Re: 163 RV Storage – PA23-016 – Technical Review 2

After review of the preliminary Site Plan Review, the Planning Division has the following comments:

RE: 163 RV Storage, File# PA23-016
RV / Boat Storage, Self-Storage & Office
Parcel #'s 31052800301600 & 700

MASTER SITE PLAN

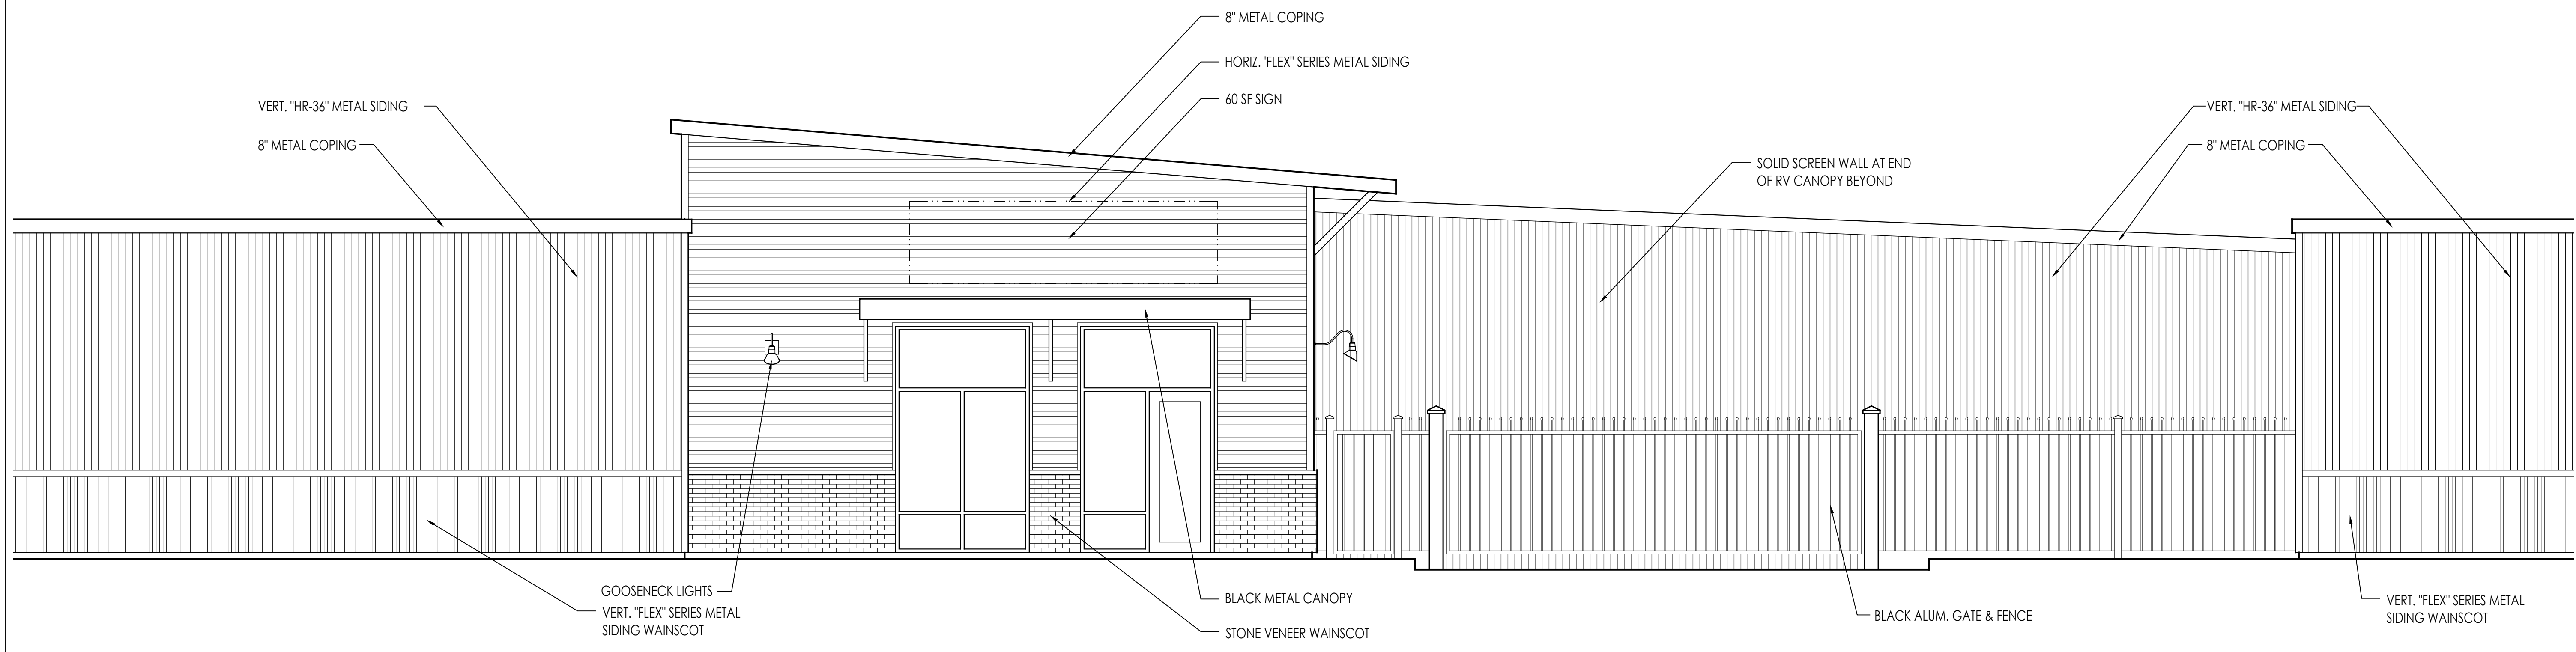
1. The proposed trash enclosure may not be located within a building. Trash enclosures must be sited and designed in accordance with [MMC 22C.120.160](#) and [MMC 22C.020.320](#). Please contact Kristy Beedle, Solid Waste Supervisor (kbeedle@marysvillewa.gov or 360.363.8152) for enclosure size and design requirements.
2. Provide specifications for the proposed security fence. The plans currently do not provide the proposed height or material proposed.
3. A revised preliminary landscape plan was not provided with the latest submittal. A final landscape plan, along with a site illumination plan and irrigation plan, is required to be submitted with civil construction plan review.
4. Staff has reviewed and concurs with the findings of the Buffer Restoration Plan prepared by Wetland Resources, Inc, dated January 17, 2024.

- 5. ***The trash dumpster cannot be located within the building.***
- 6. The onsite grading and placement of any retaining walls must be compliant with section 22D.050.030 of the MMC and with Chapter 3 of the EDDS.
